MIDDLE LEVEL COMMISSIONERS

Our Ref : GM/346/PL/1542
(Please quote this reference on any correspondence)

Hundred of Wisbech Internal Drainage Board

Relevant Representations for Medworth Energy from Waste Combined Heat and Power Facility Development Consent Order at Algores Way, Wisbech - Medworth CHP Limited (MCL)

**Figure 6.1**  
**Water Connections layout**

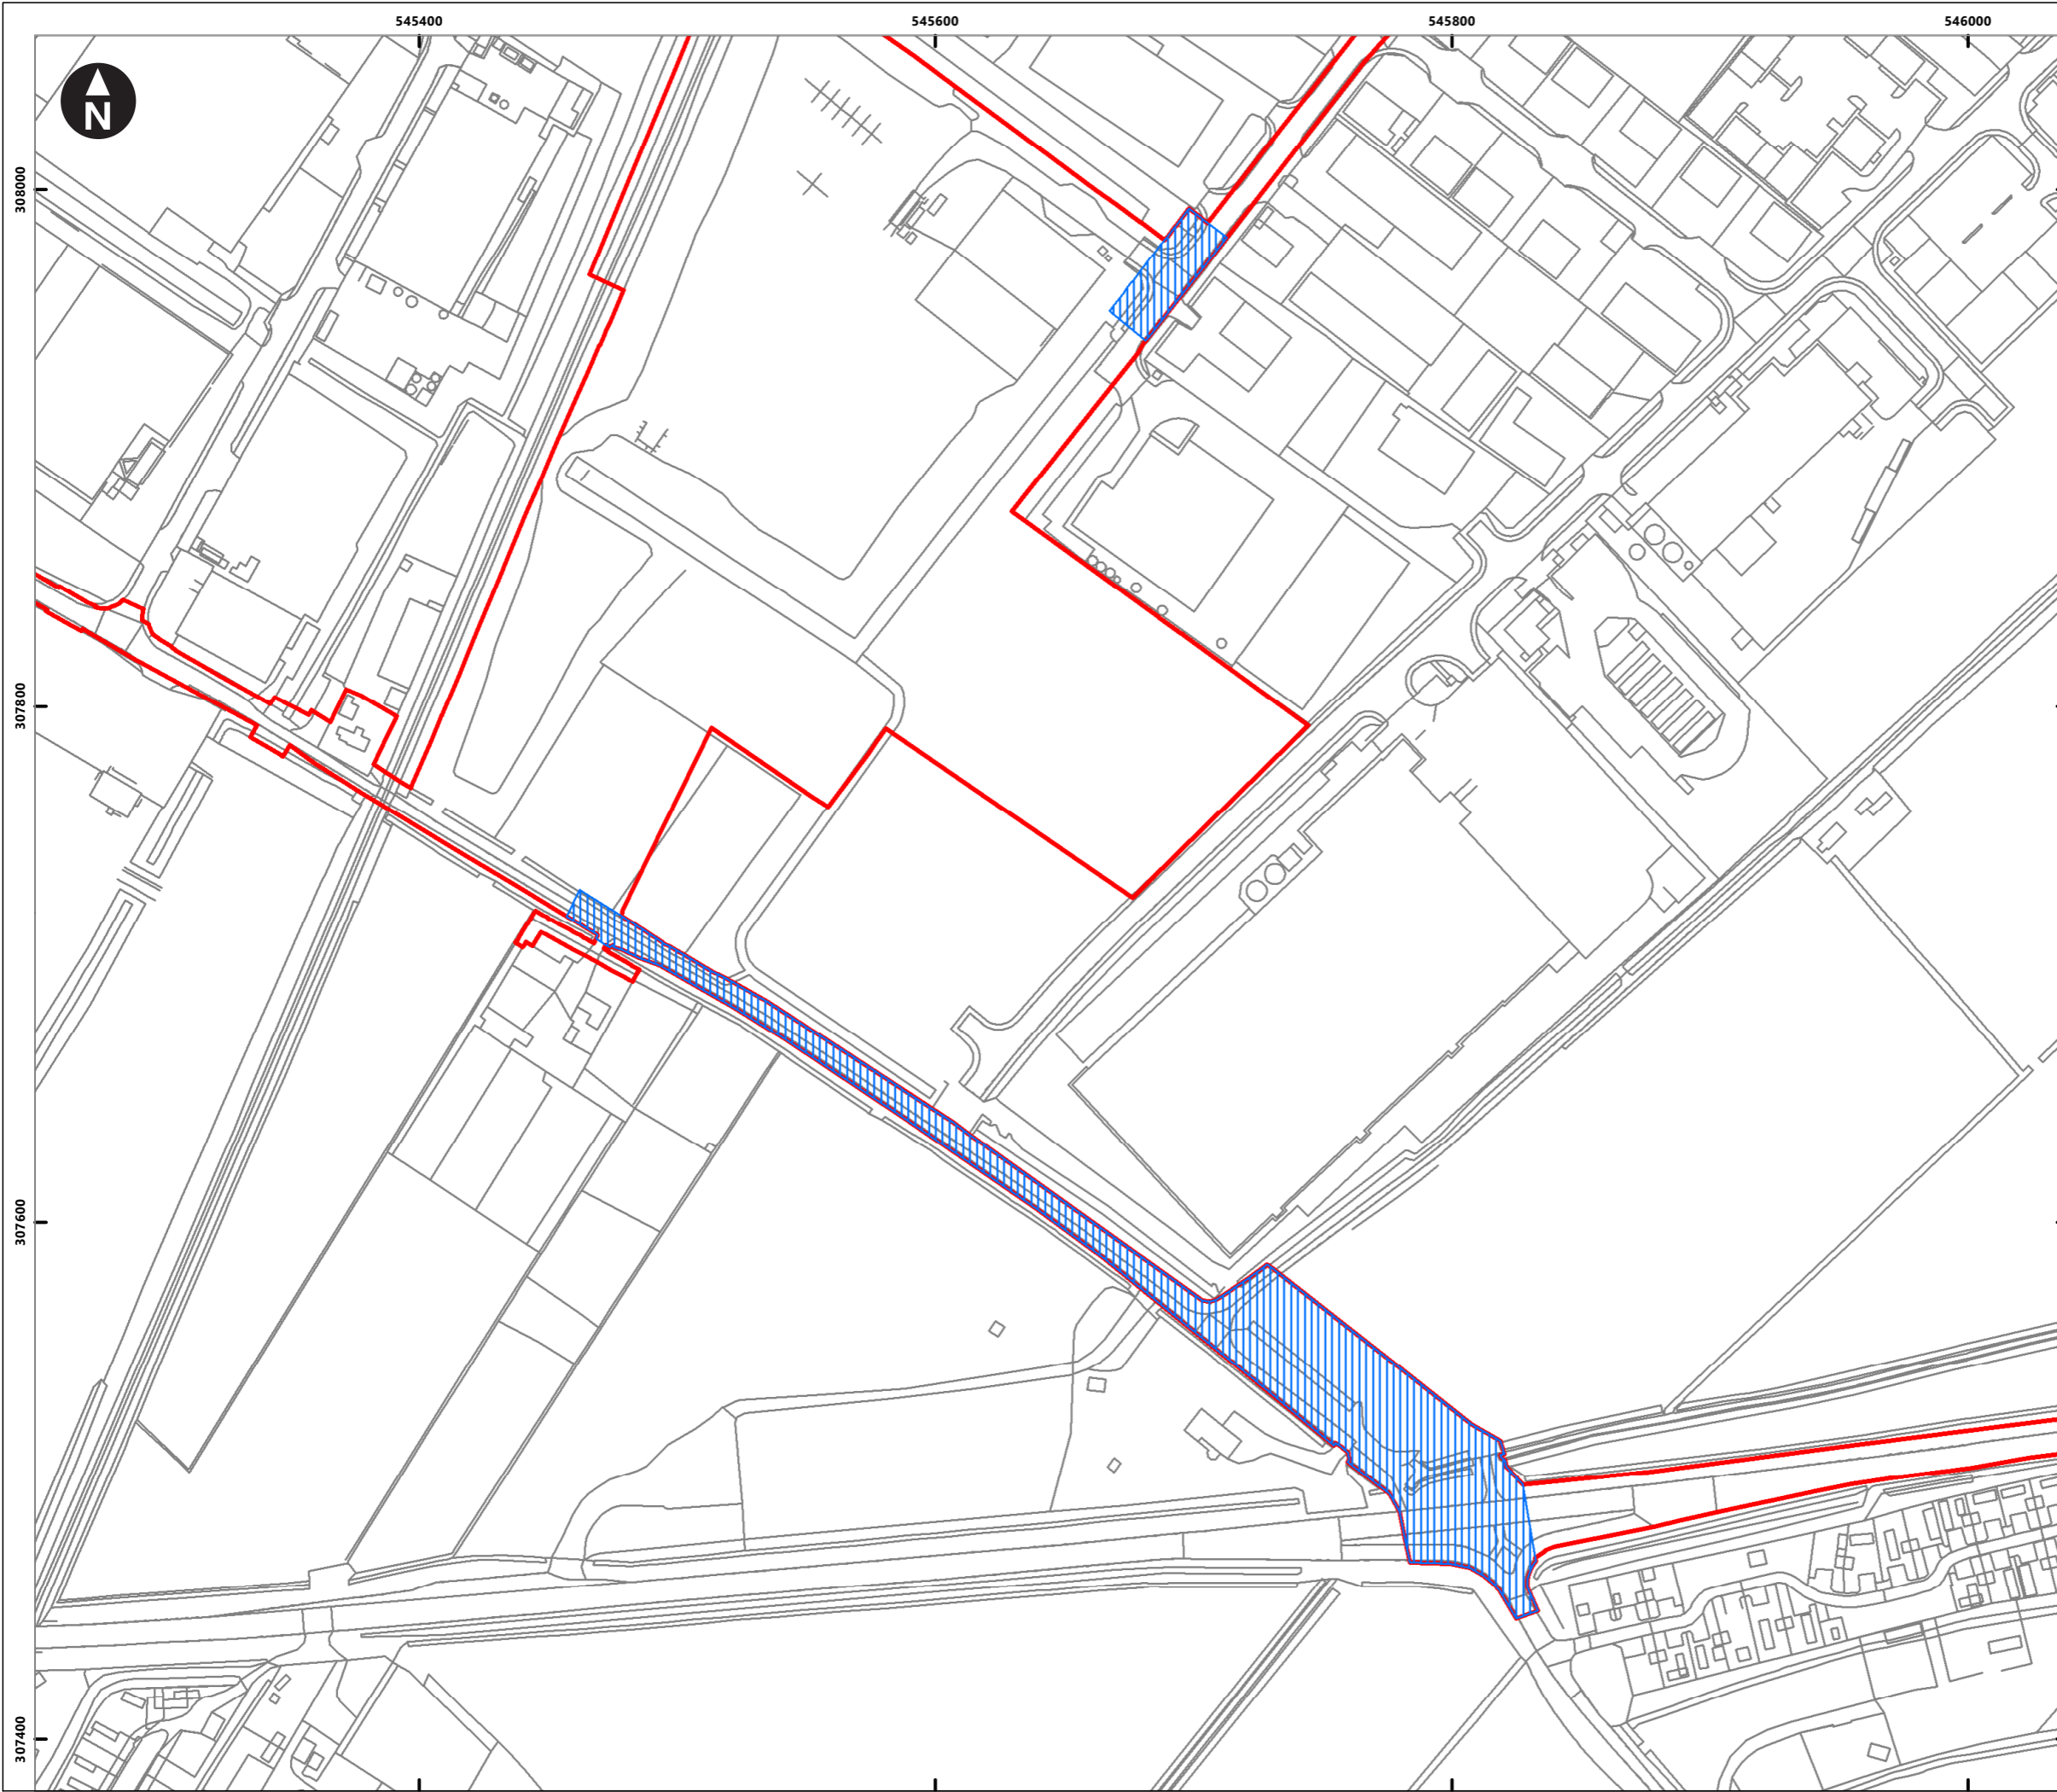
Of prime concern to the Board is the culvert under the A47 at Point 50 which is of strategic importance as it is the main point of discharge for the large urban area of southern Wisbech. It is the confluence of several Boards Drains and is currently constrained by a combination of poor geometry of the watercourses and culverts and the gas main that dog legs across the Board systems in the area the presence of which necessitated that pipeline on the north eastern side of New Bridge Lane being installed at a less than ideal level.

The proposed electricity grid and water connections add to these existing constraints.

Concern about the water connection has been discussed and whilst it is not the ideal location the Board would prefer an open cut trench across the A47 rather than the HDD connection to the north east of Point 50 as this will further constrain an increasingly important location which may be subject to significant changes if the aspired roundabout is built nearby.

**Figure 10.1i**  
**New Bridge Lane access design**

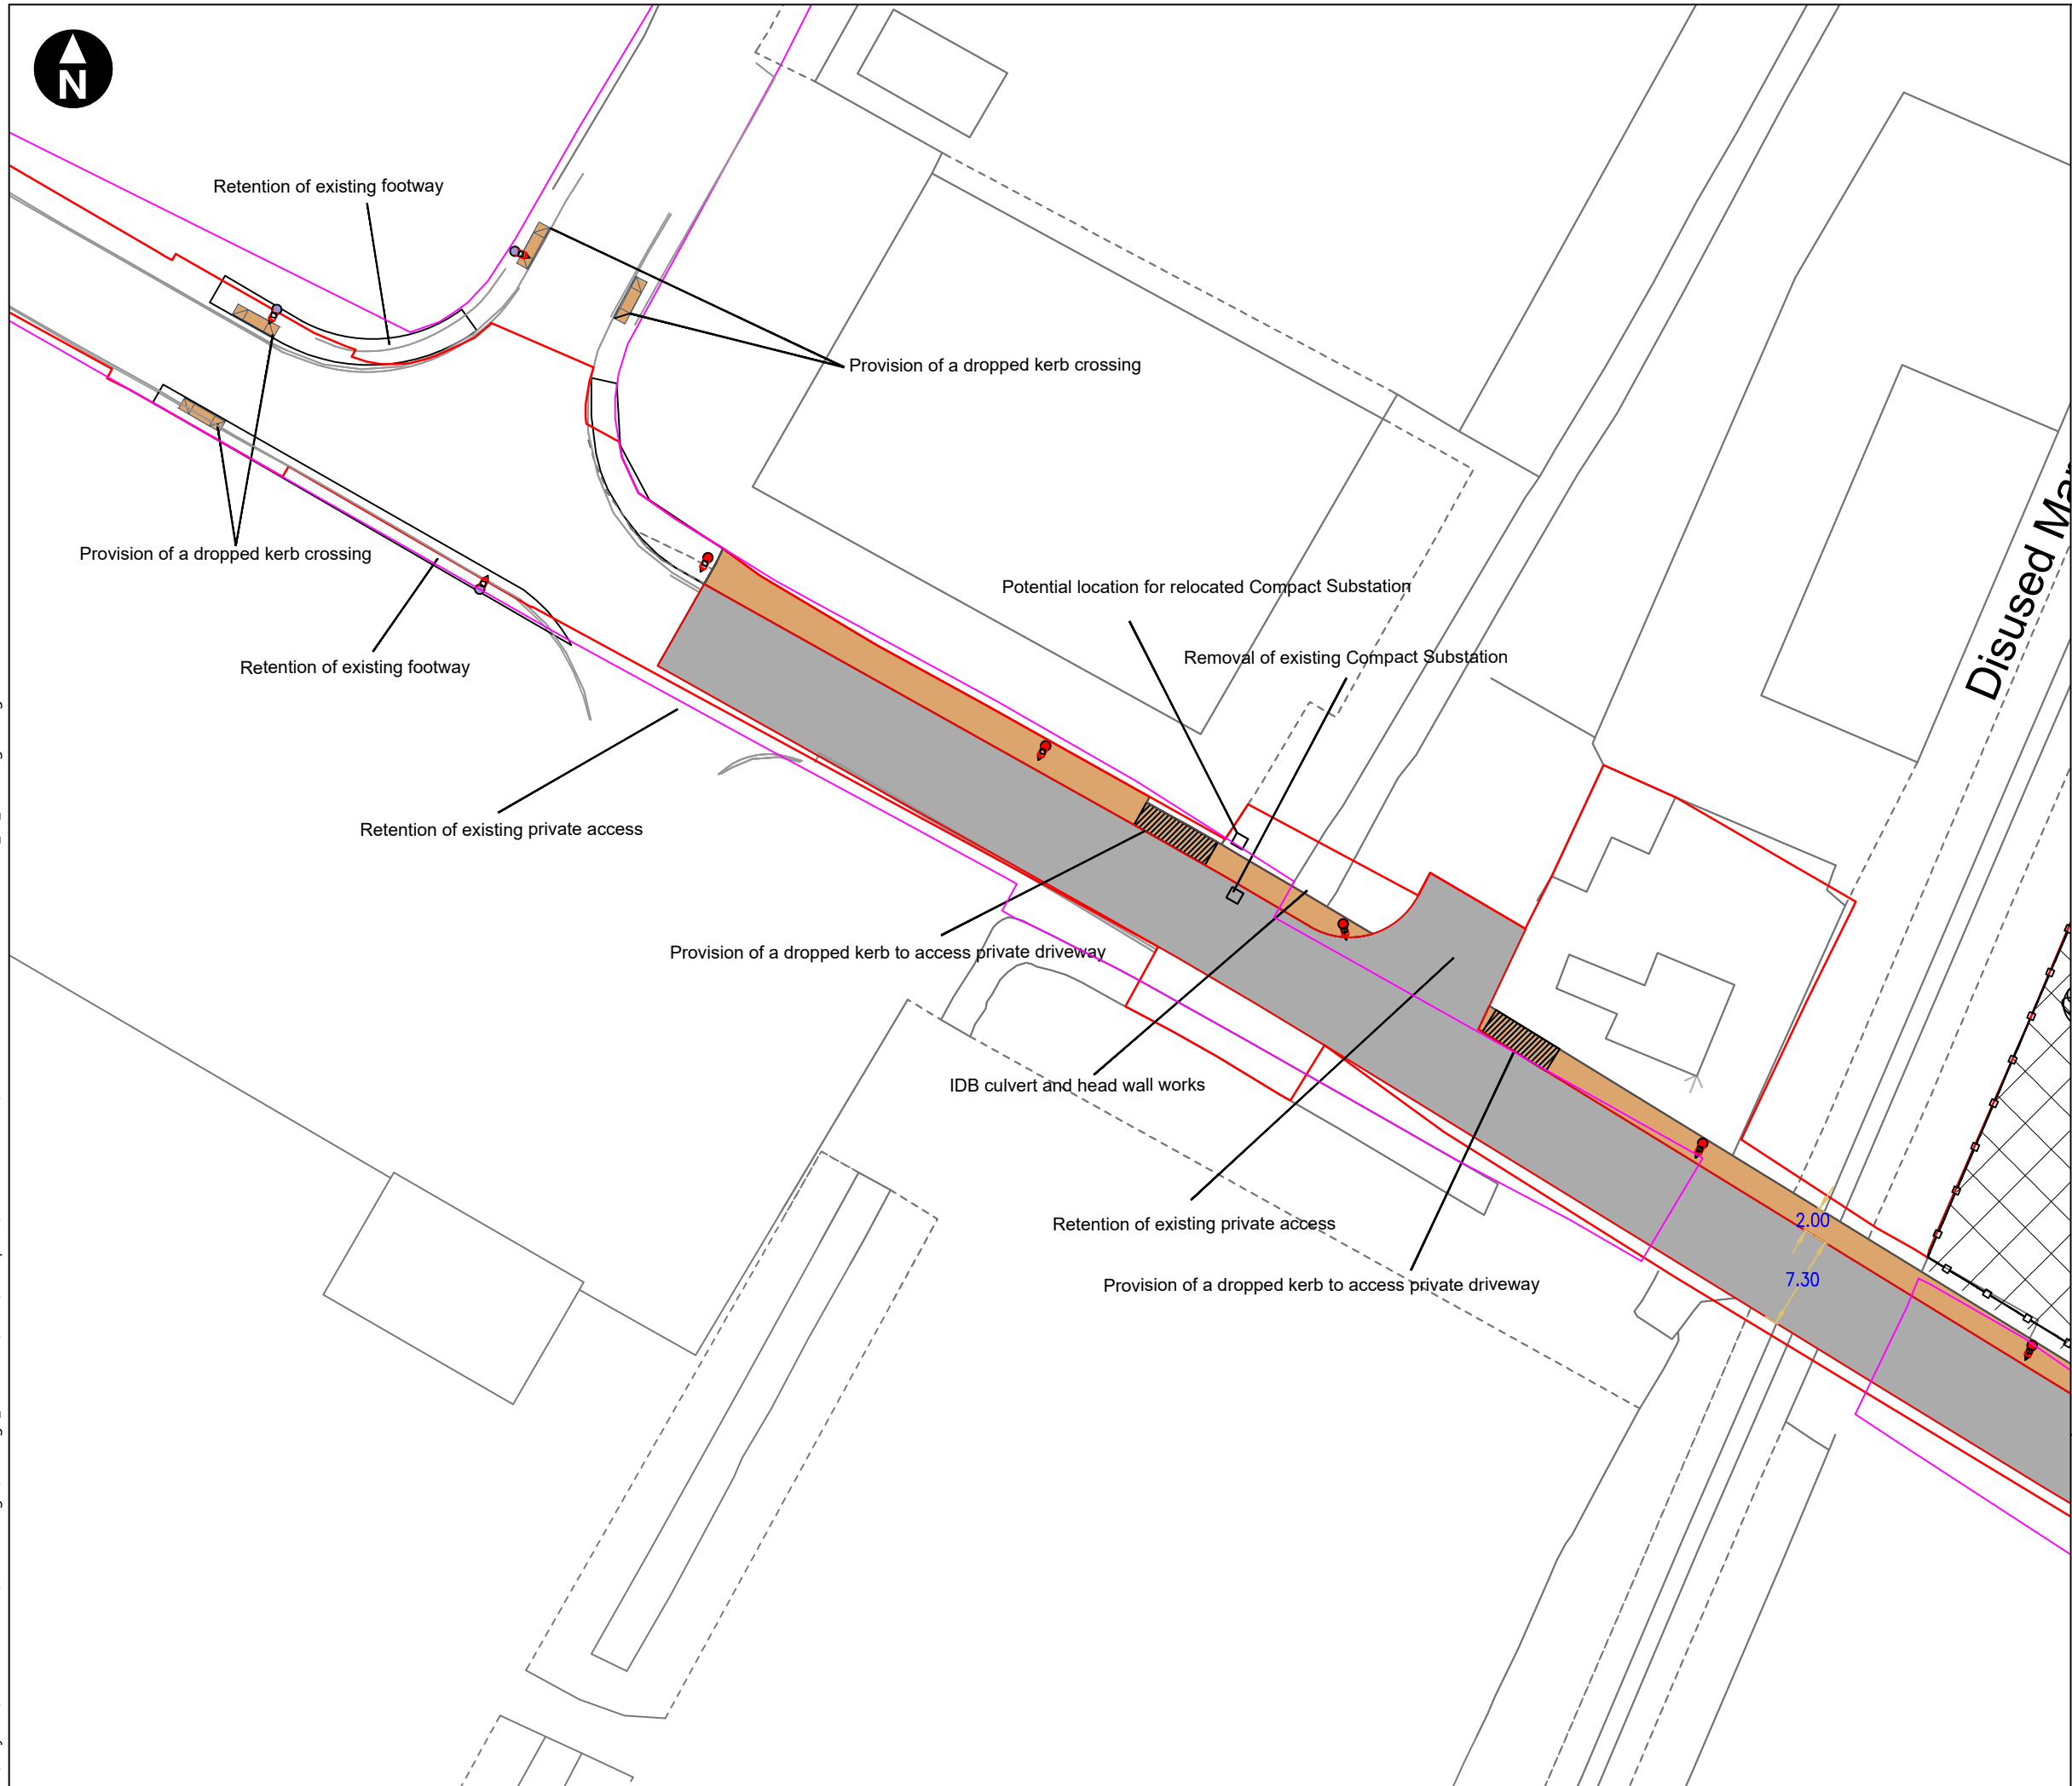
The Boards Cromwell Road Drain is culverted under the Lane to the north west of the crossing with the "mothballed" railway (Point 31). This watercourse forms an important part of the Boards network serving the urban area generally bound by the River Nene, Weasenham Lane, the railway and New Bridge Lane. This culvert was installed several years ago and is approaching the end of its life. In view of this and the increased HGV Traffic loading it is considered that this culvert should be replaced with a new structure.

Currently access to it is largely unrestricted and the Board can undertake routine maintenance on this watercourse relatively easily from the field and roadside. Unfortunately, the increased volume of traffic using the Lane together with the proposed street lighting, chicane and acoustic fencing to a property on the southern side of the Lane, would make future maintenance operations more difficult increasing the risk of conflict and accidents; will reduce safety of the Boards employees/contractors and other road users; and require alternative methods of working with potential increased costs on the rate payer and possibly delaying vehicles entering and leaving the facility.

The vibration resulting from the increased traffic may lead to failure of the channel profiles which increases costs in undertaking remedial works and could, in the correct circumstances, lead to blockages restricting flows within the channel increasing flood risk.

There is also a watercourse on the northern side of the highway which will require repositioning if the proposed widening of the Lane occurs.

No reference is made to the drainage system serving the widened road or any adverse impacts upon it given that the County Council do not currently adopt SuDS features and that the Boards system is considered to be close to capacity and will require all discharges to be attenuated to greenfield rates of run off.

The impacts of widening Newbridge Lane in relation to the adjacent watercourses and culverts and proximity to the highway in terms of construction, operation and safety will require greater clarity and detail in due course.
